# PORTLAND MAINE

**RE:** Review Comments for Final Single Family Plan, 11 Pomeroy Street

Thank you for submitting a Level I: Minor Residential site plan application for your proposed single family residence at 11 Pomeroy Street. This proposal is being reviewed as a final plan and subject to the following applicable Land Use Code provisions:

**TO:** Nell Donaldson, Planner  
**FROM:** David Senus, P.E. & Ashley Auger, E.I.T.  
**DATE:** May 30, 2012  
**RE:** Pomeroy Street Construction, Level I & II Site Plan Application

SITE PLAN
LEVEL I-MINOR RESIDENTIAL DEV.
LEVEL II-ROAD IMPROVEMENTS
LAND OF
CHABAD LUBAVITCH OF MAINE INC.
POMEROY STREET
PORTLAND, MAINE

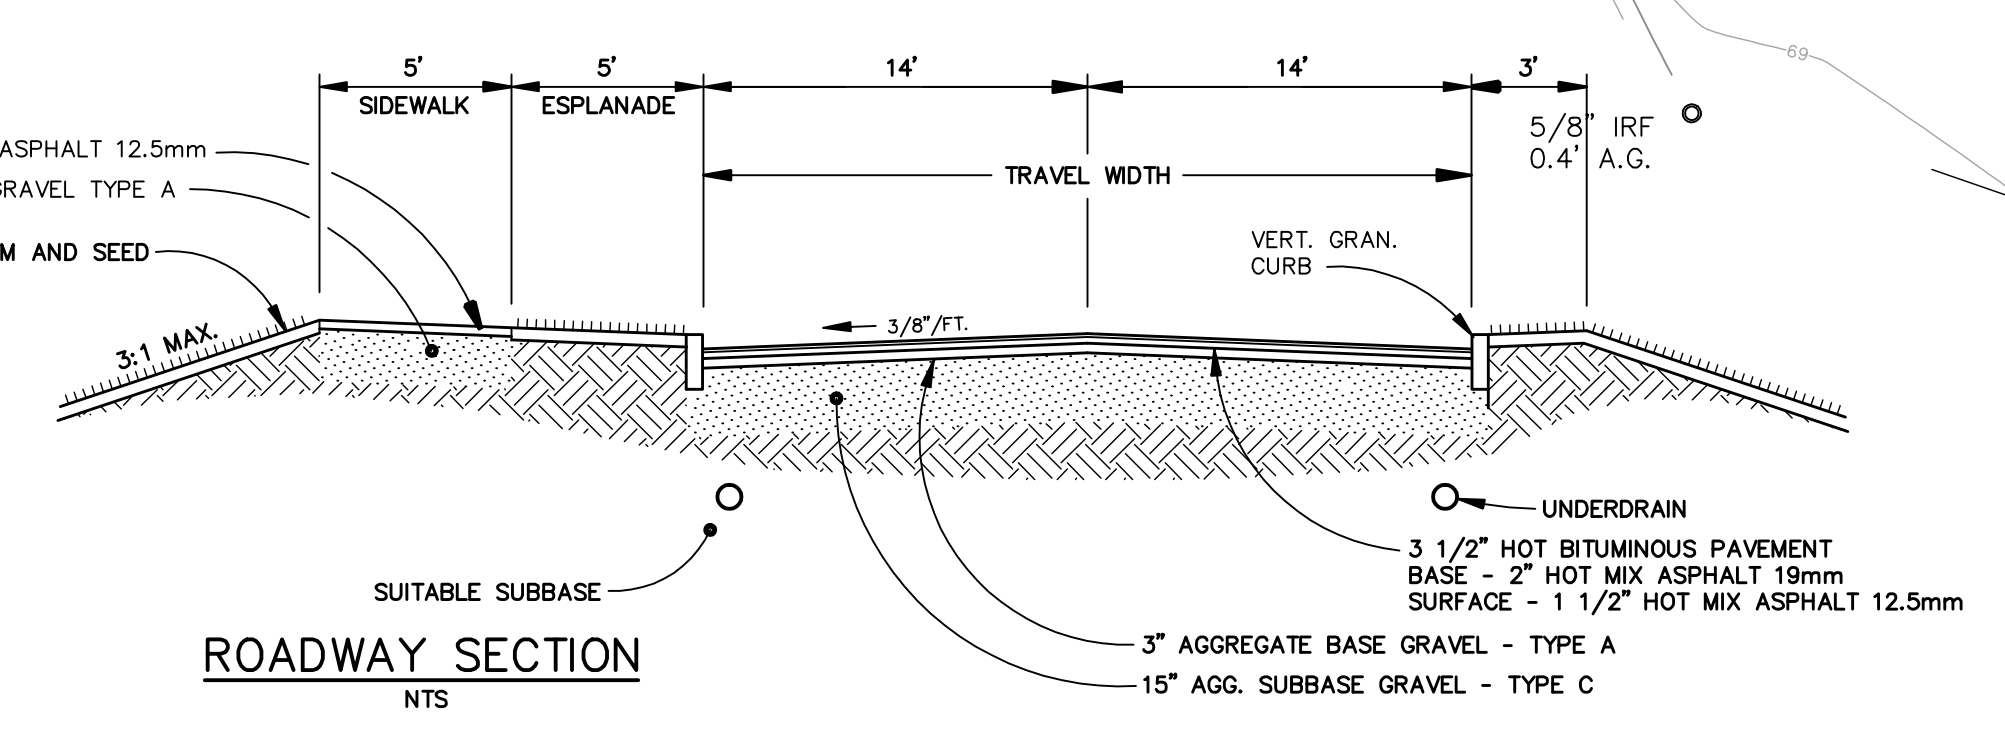
- A written description of the outsale of the land that will be recorded at the registry of deeds.
- That the site plan show the footprints of the three porches that are shown on the building plans.

1. Updated site plans to include:
  1. Distances to property lines
  2. Limit of disturbance
  3. Foundation/perimeter drain outlet
  4. Existing vegetation to be preserved
  5. Proposed site landscaping
  6. Accurate portrayal of building footprint (including porches)
2. Updated NRPA Tier 1 permit
3. Written description of existing easement on north side of property
4. Information regarding site lighting. As a reminder, exterior lighting should be full cut off.
5. Final site plans for the construction of Pomeroy Street under Section 14-403 of the city's ordinance
6. The Planning Authority may request additional information during the continued review of the proposal according to applicable laws, ordinances and regulations.

2. Proposed pipe into existing sanitary manhole does not meet Technical Manual standards.
3. Please add note to plans that all work within the proposed Pomeroy Street right of way shall meet City of Portland Technical Manual standards.

4. A turnaround is required at the end of the proposed street. Please define with easements.
5. Drain manholes shall channels installed.
6. All precast structure castings shall meet be per Technical Manual requirements or approved equal.

- 3) The Site Plan proposes two drainage pipe inlets located on either side of the residential driveway. These inlets have proposed invert elevations that are below the existing ground surface elevation, and are located in close proximity to existing wetlands. Surface and shallow groundwater associated with these wetland areas will likely enter the roadway drainage system through these inlets, affecting the hydrology of the adjacent wetland areas. Although review of wetland impacts will be performed by MaineDEP, the addition of this "non-contaminated" water source into a drainage system that discharges into the City's combined sewer is not allowed unless approved by the City Engineer (Section 2.1.1 of City of Portland Technical Manual).

STANDARD BOUNDARY
 SURVEY AND EXISTING
 CONDITIONS PLAN
 LAND OF
 CHABAD LUBAVITCH OF MAINE INC.
 POMEROY STREET
 PORTLAND, MAINE

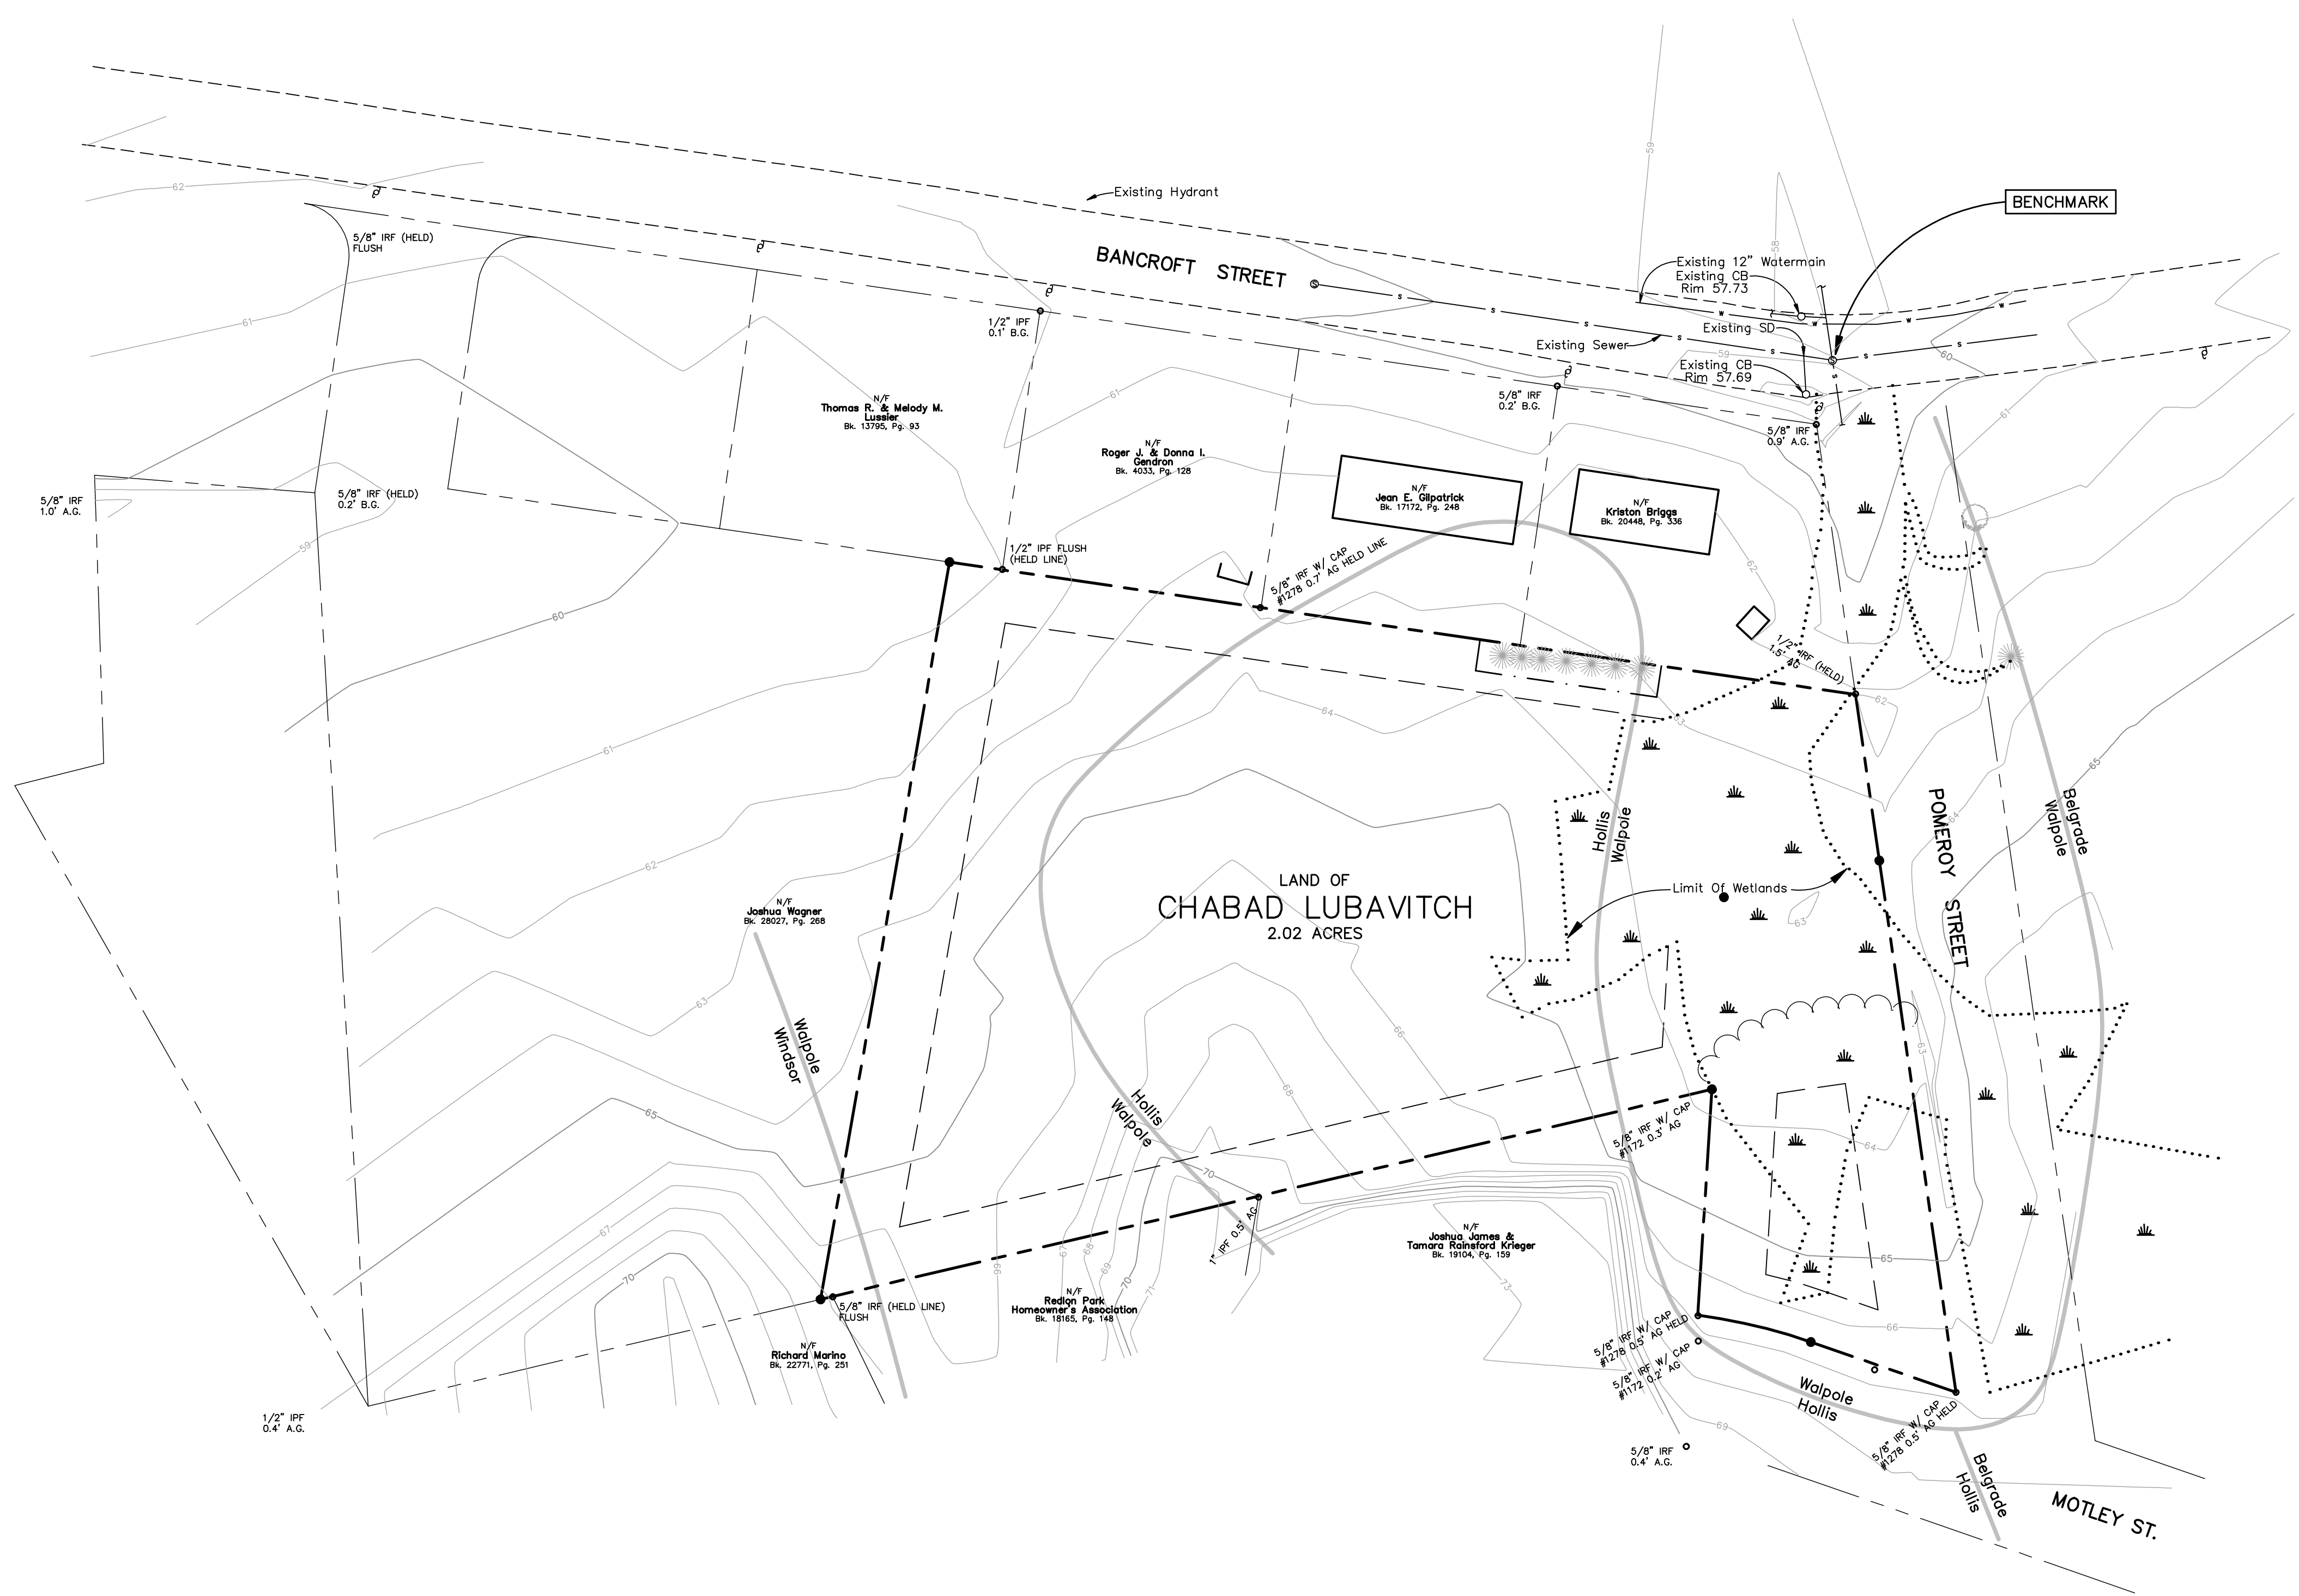
9. On Sheet 1 please indicate the status of the streets shown, i.e. accepted, vacated, paper, etc. A separate survey plan for acceptance is suggested.
10. Sheet 1 needs to be on the Maine State Plane for acceptance.

11. Sanitary manhole rim are not acceptable as an official city benchmark.
12. As shown, are drainage easement required? (Danielle)
13. Need to define the area of Pomeroy St. to be accepted with linework, bearings and distances and granite survey monuments.

VERTICAL GRANITE CURB DETAIL
N.T.S.

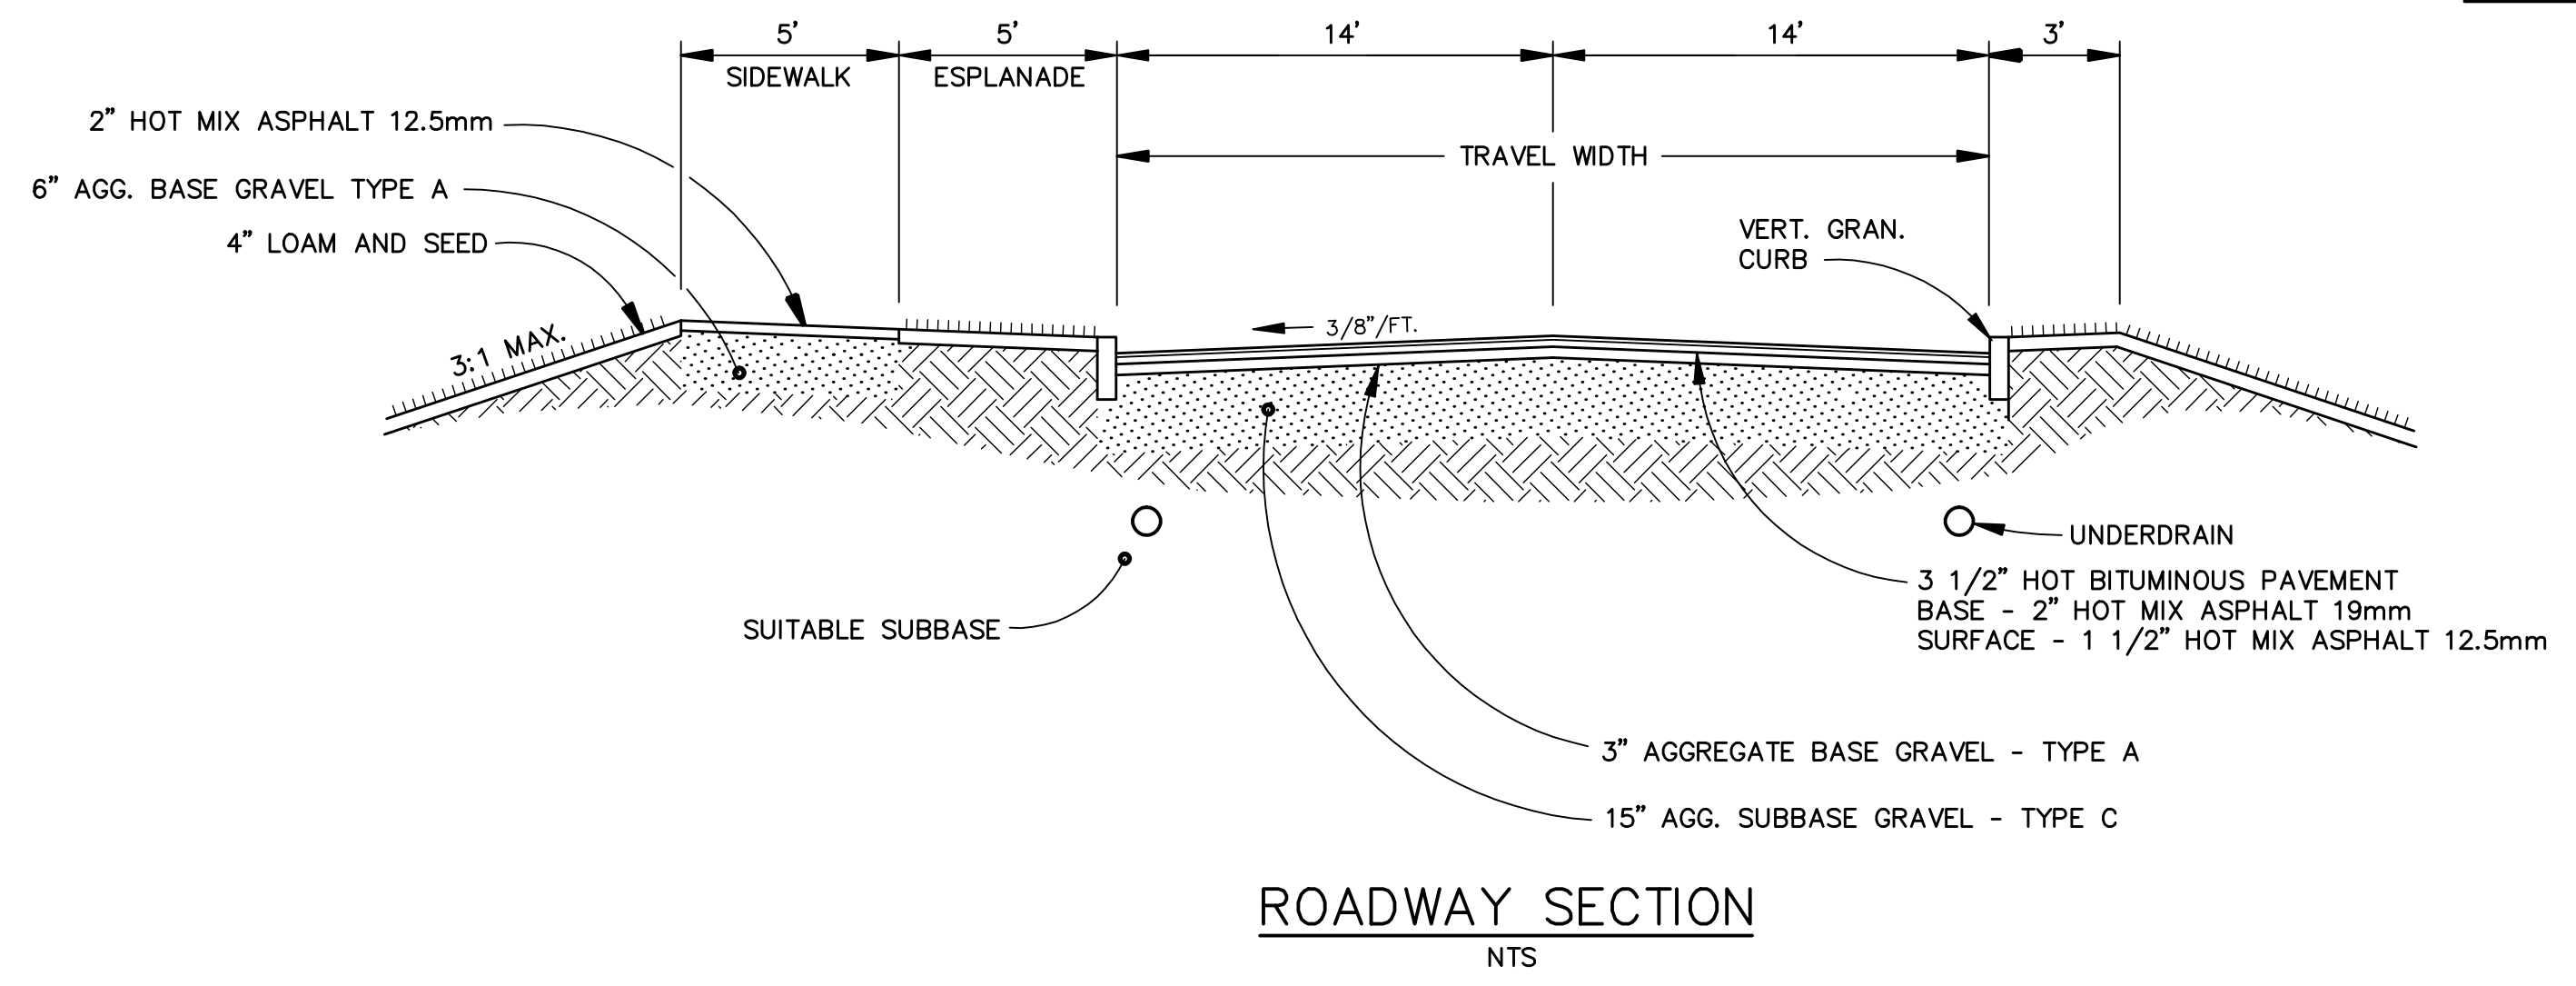
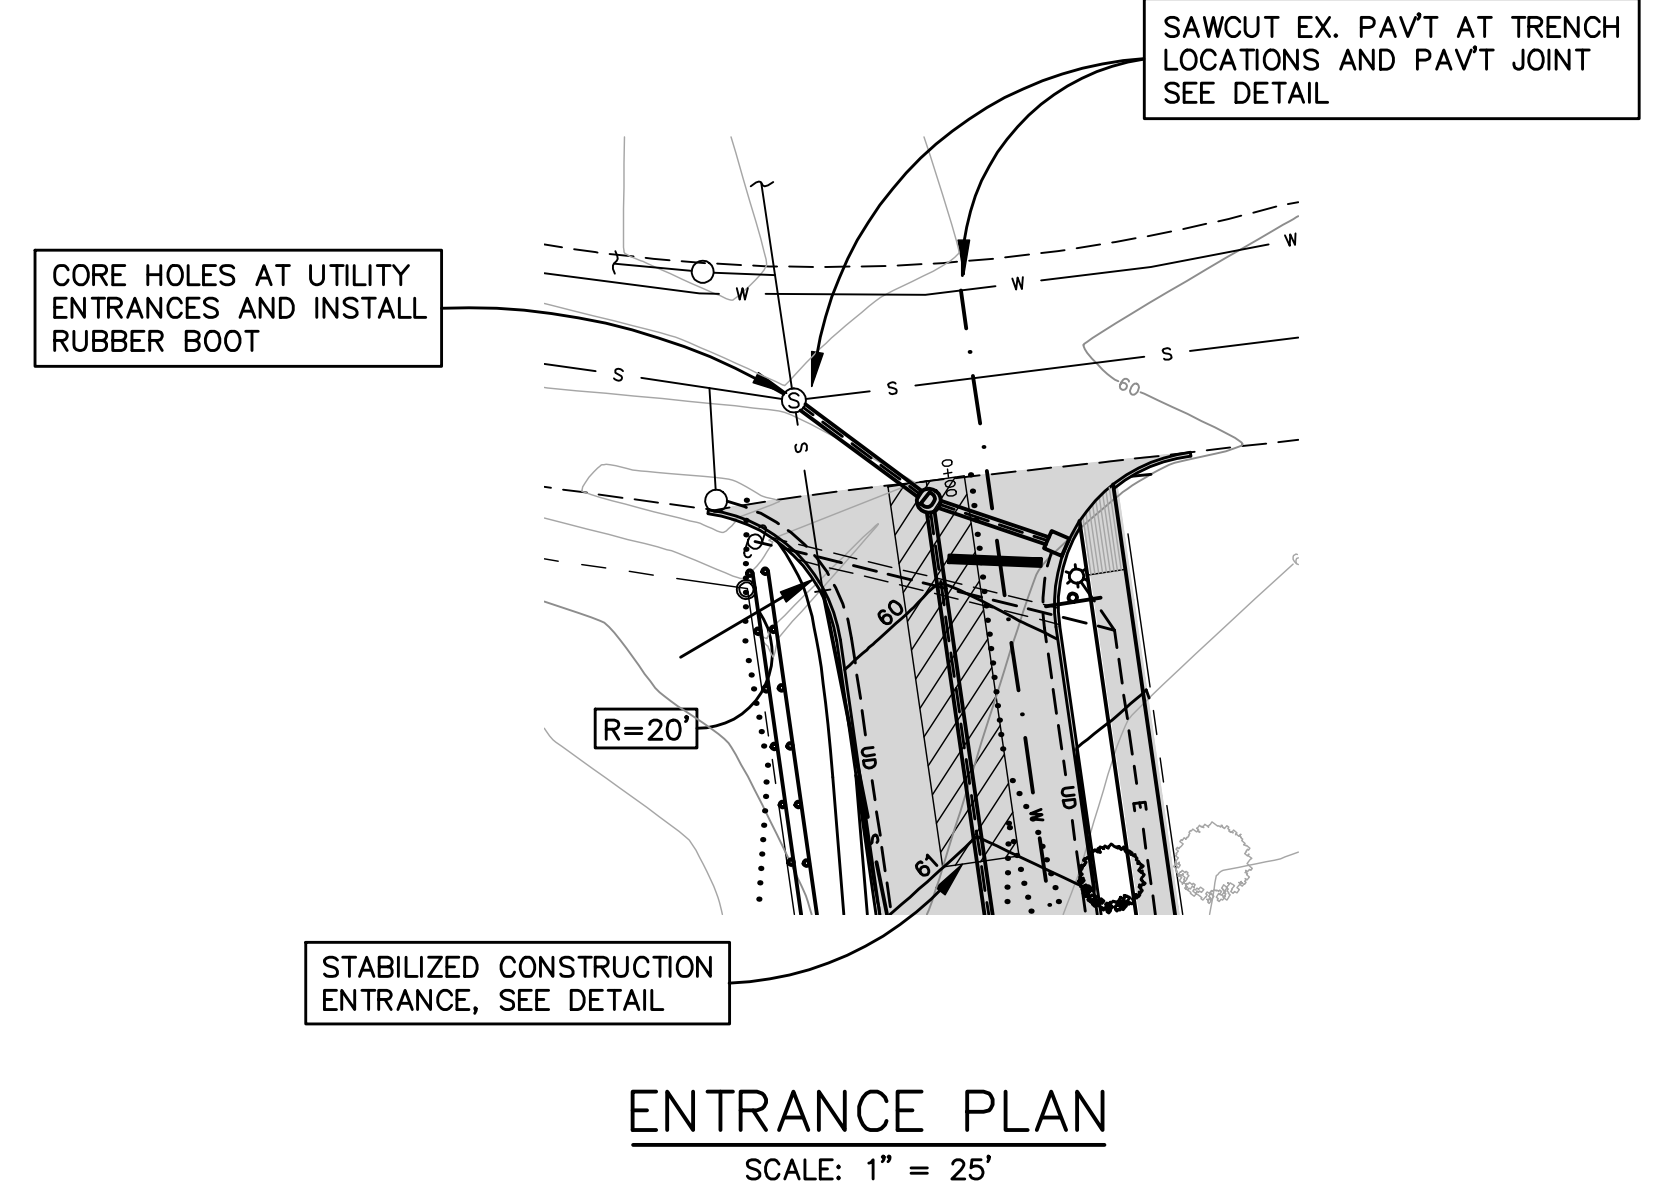
- b) Vertical Granite Curbing and Terminal Curb details should be per Figure I-16.
- 5) In accordance with Section 2 of the City of Portland Technical Manual:
